Re: Objection to MP08_0244 MOD 1 Modification Request for Mixed Used Development at 23-37 Lindfield Avenue and 11 Havilah Lane, Lindfield

Major Projects Assessment
Department of Planning and Infrastructure
GPO Box 39, SYDNEY, NSW 2001

1 SHADOW DIAGRAM - 21stDEC_9AM
5003 SCALE1 : 650

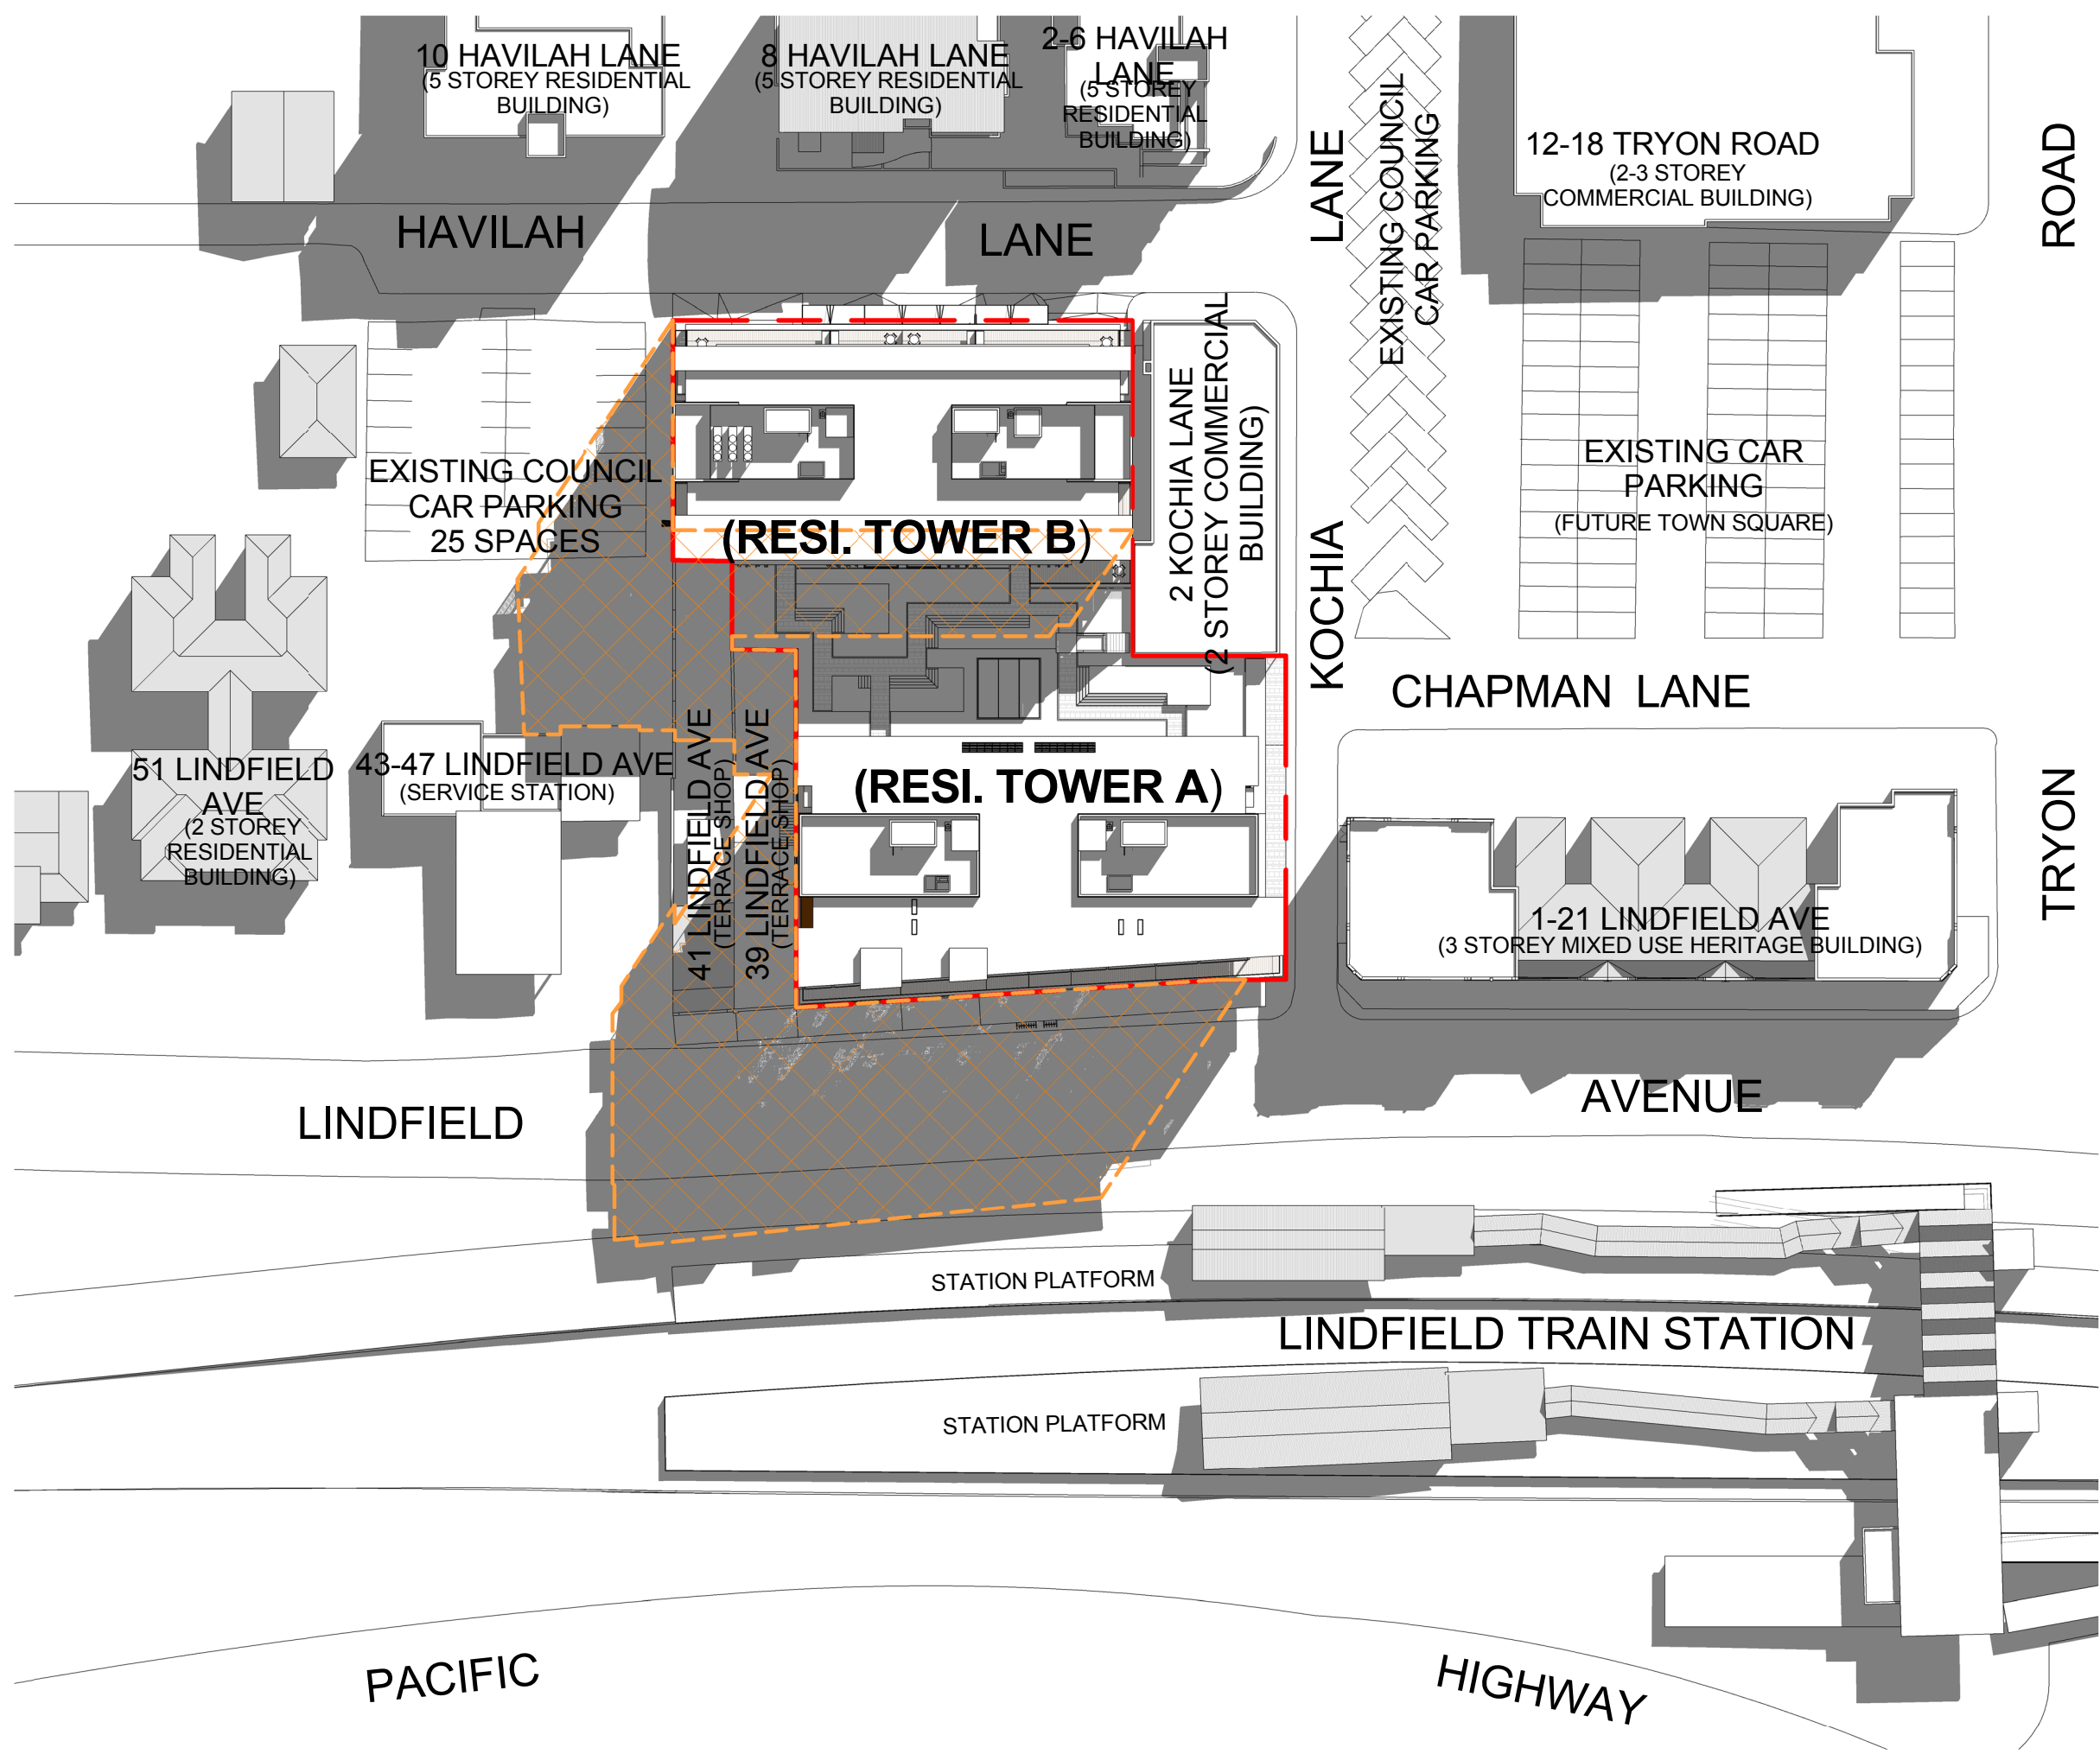
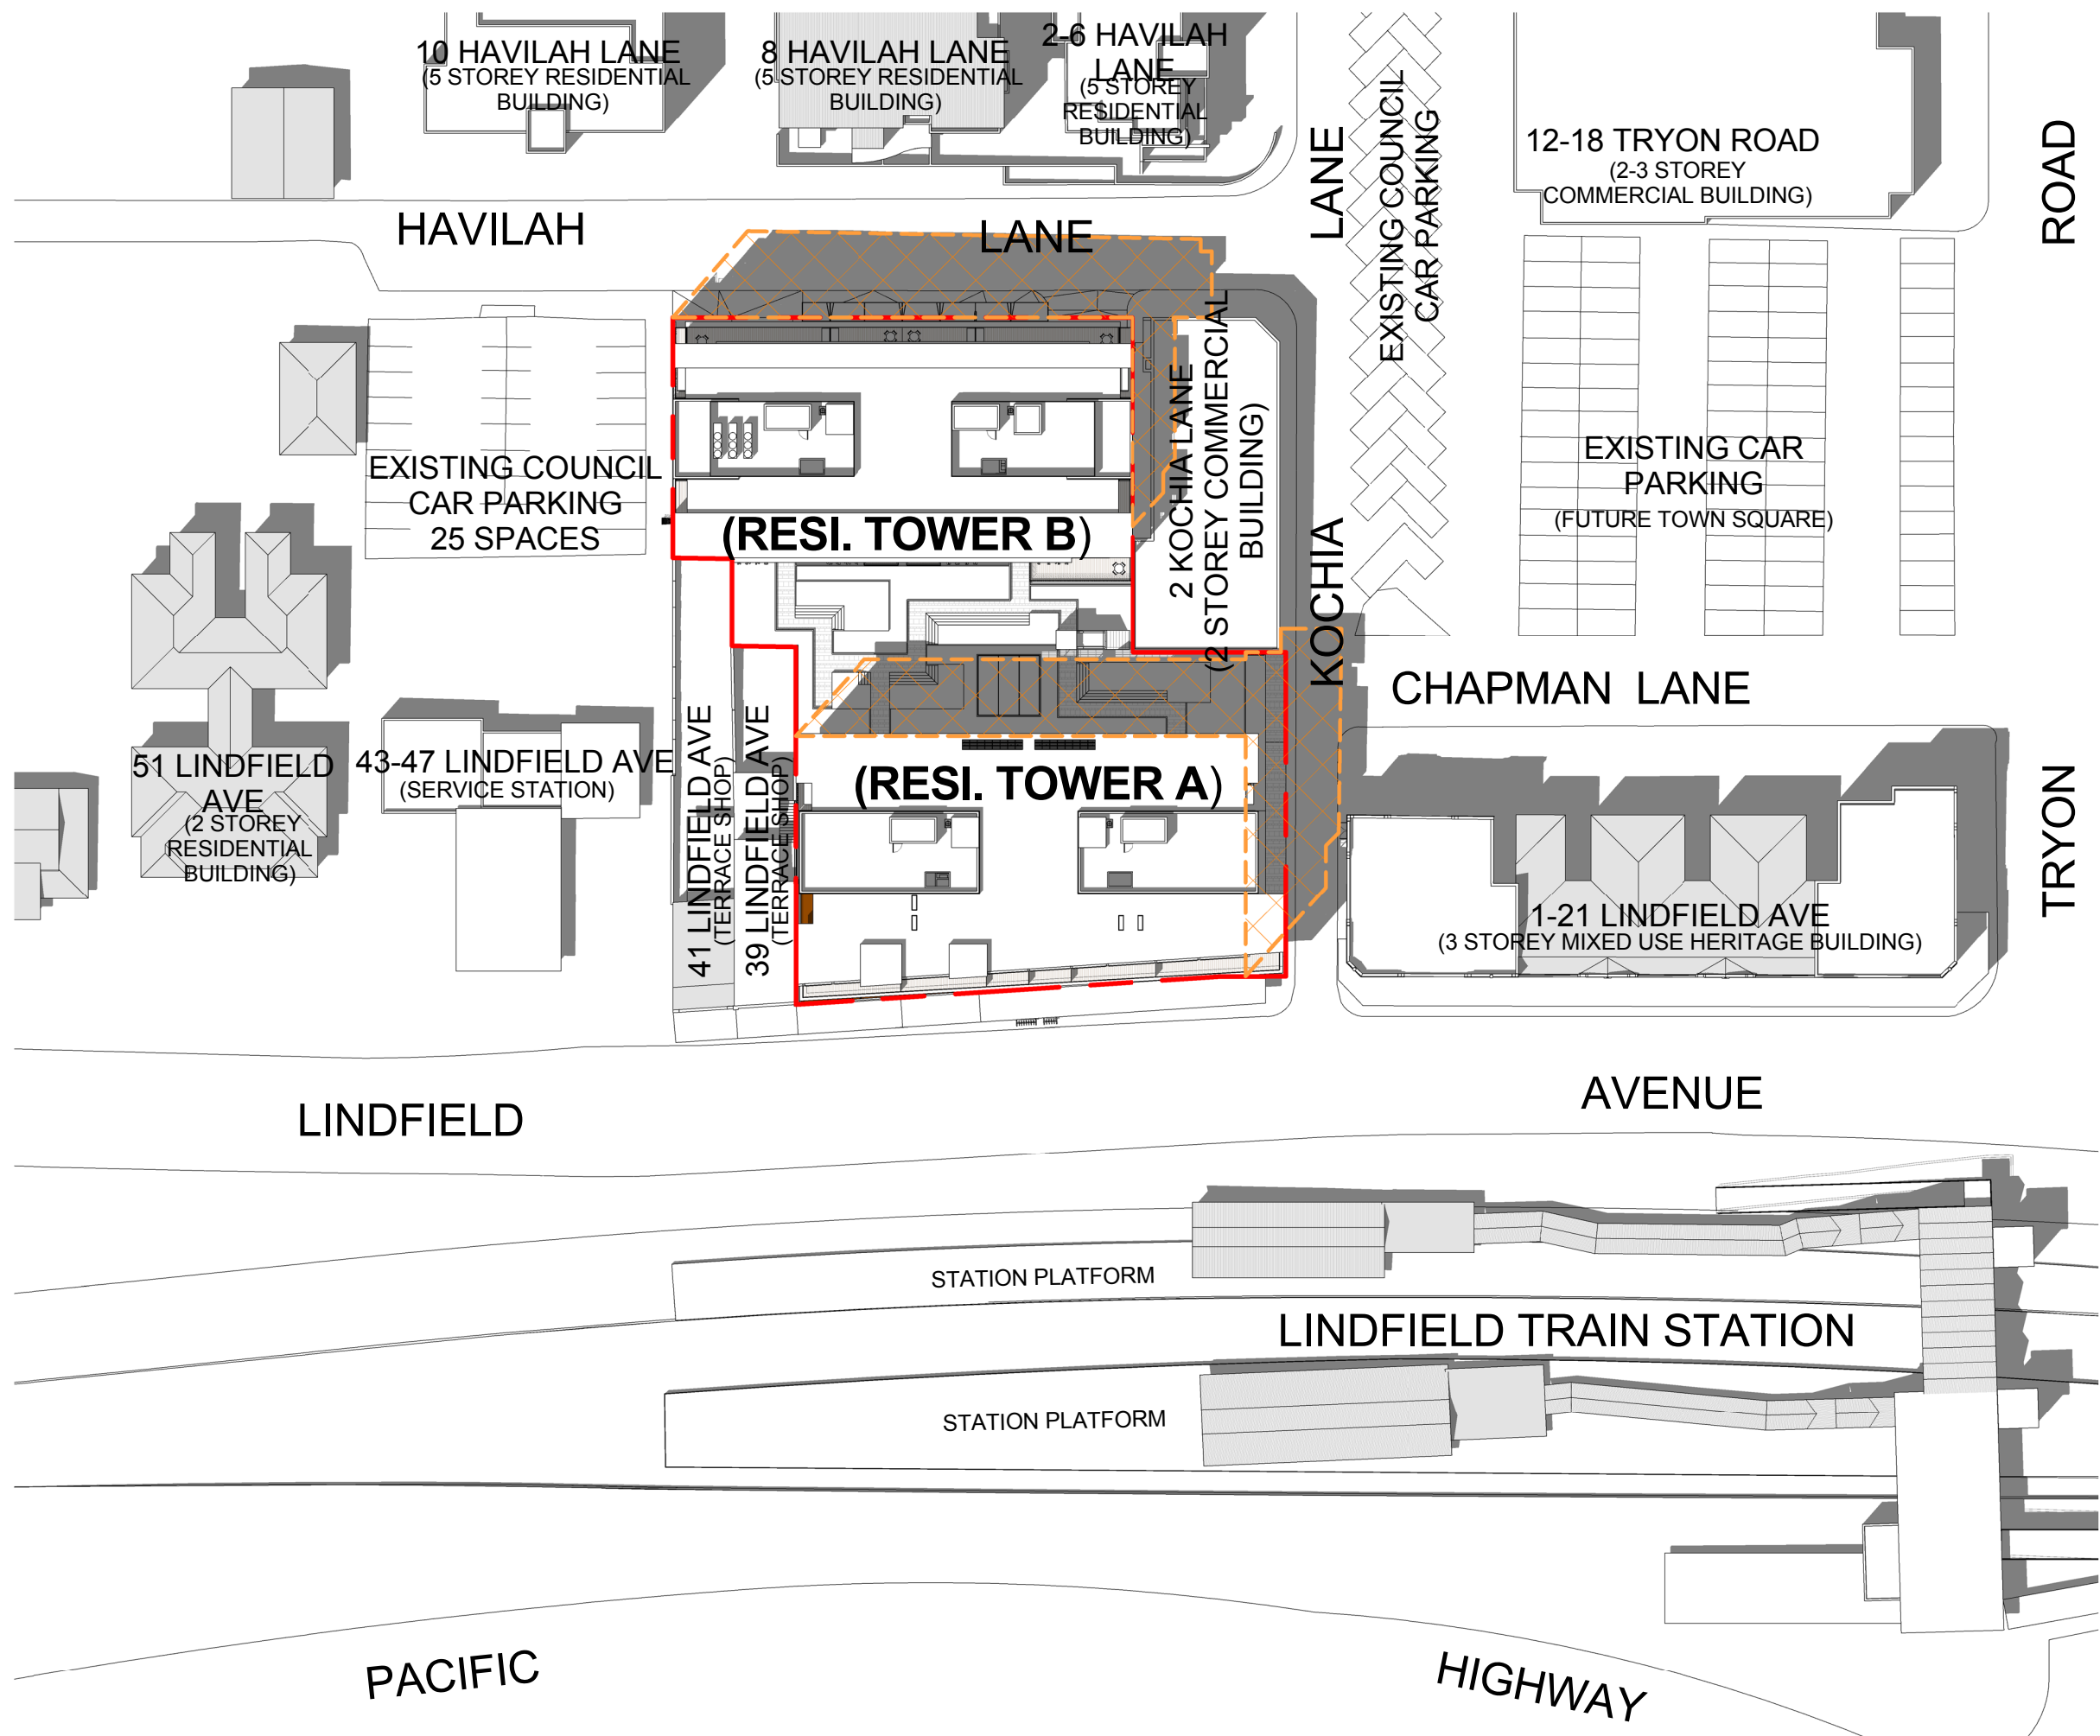
- The additional storeys create new adverse shadowing: a) for residents in the Havilah Lane apartments, particularly after 3pm b) for the popular outdoor café and central Lindfield hub area at 12 Tryon Road in afternoons, particularly in winter and c) for all commuters on the city bound Lindfield rail platform, instead of 50% of the year as approved, it will now be in shadow in the mornings 75% of the year
